From: Anita Gardner
Sent: 08 February 2018 09:04
To: Karen Parsons
Subject: FW: AB/143/17/L and AB/142/17/HH - 7 Old Poor House Cottages, Mount Pleasant, Arundel

The conservation officer has responded today. Her comments are as set out below. There are no minor changes that can be made to application to address her comments and therefore both applications will proceed to refusal.

The proposal site is within Arundel Conservation Area, and is Grade II Listed Wash-house to the historic Poor House complex.

PROPOSED SITE / ROOF PLAN

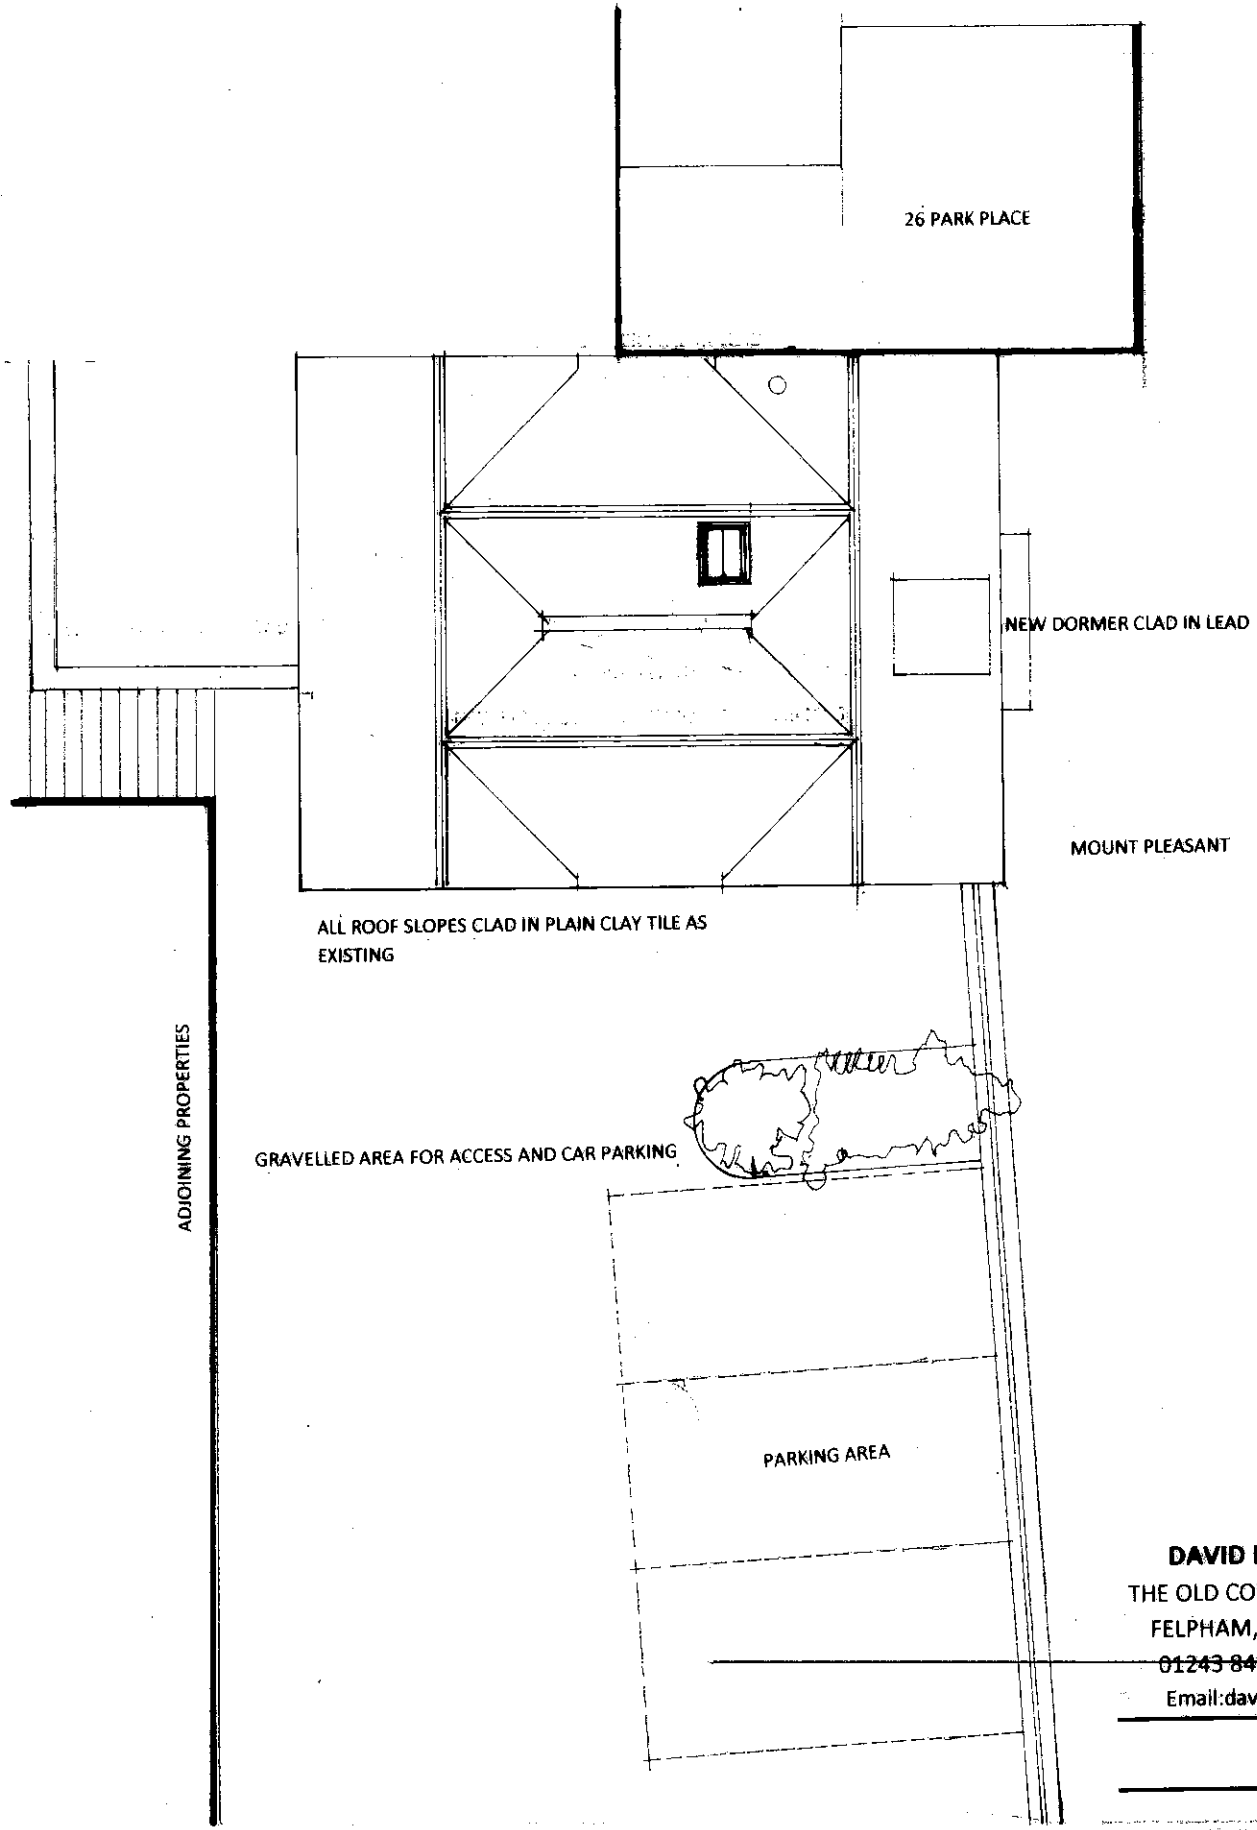
floor level. This would result in the floor joists appearing/crossing the window. It is not clear how the applicant wishes to address this element to achieve BRegs, in a satisfactory manner suitable for a Listed Building. It is proposed to insert a dormer window to first floor, requiring removal of historic fabric, removing the balance of visual symmetry, representing intrusion to the intended roofline and is detrimental to the street scene as atypical of a single storey building of this type.

PROPOSED CROSS SECTION

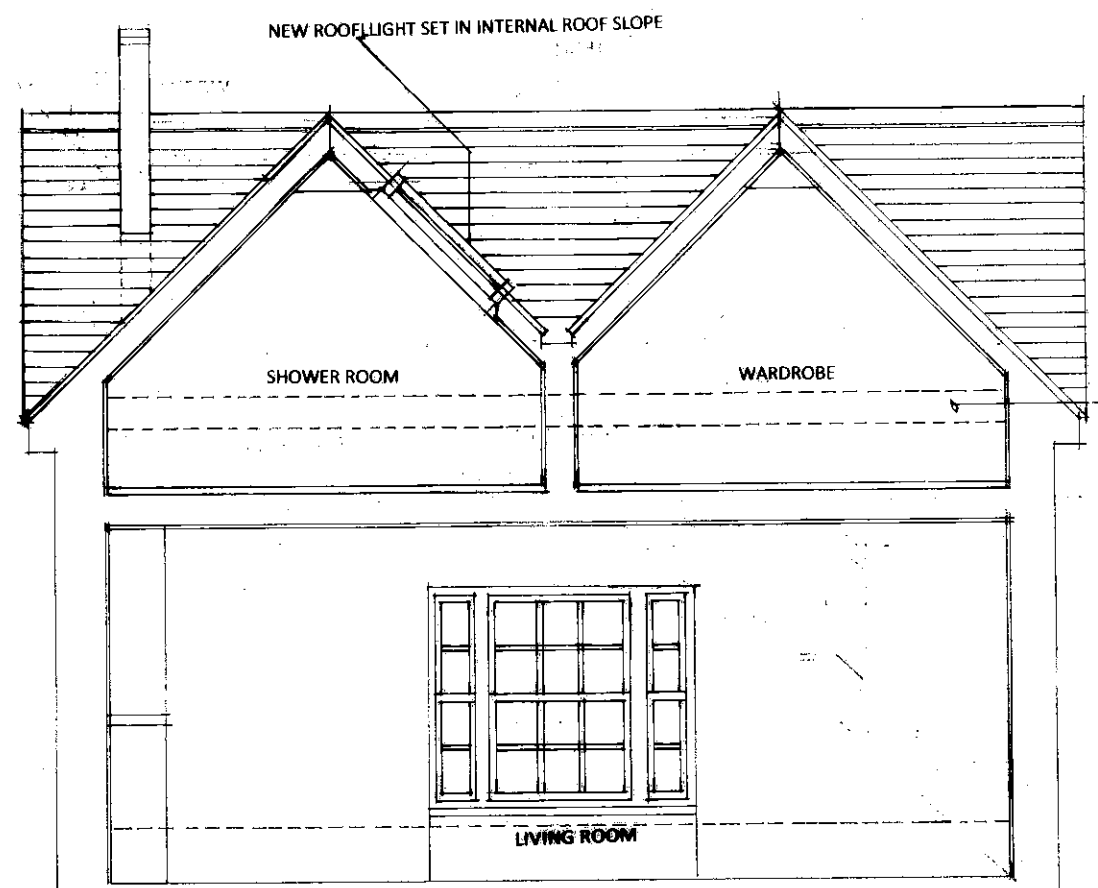
The proposal is to introduce an upper floor, and insert ground floor bathroom. This requires removal of walls, whose age has not been ascertained and removal of concrete (non historic) floor to allow bathroom to issue into living room at one level. The insertion of the upper floor requires removal ground floor (historic) ceiling to lower the floor level to achieve head height at first floor level. Insertion of staircase, requiring removal of original floor and joists. This stair would pass directly in front of ground floor window. The proposal is to lower the GF ceiling/FF
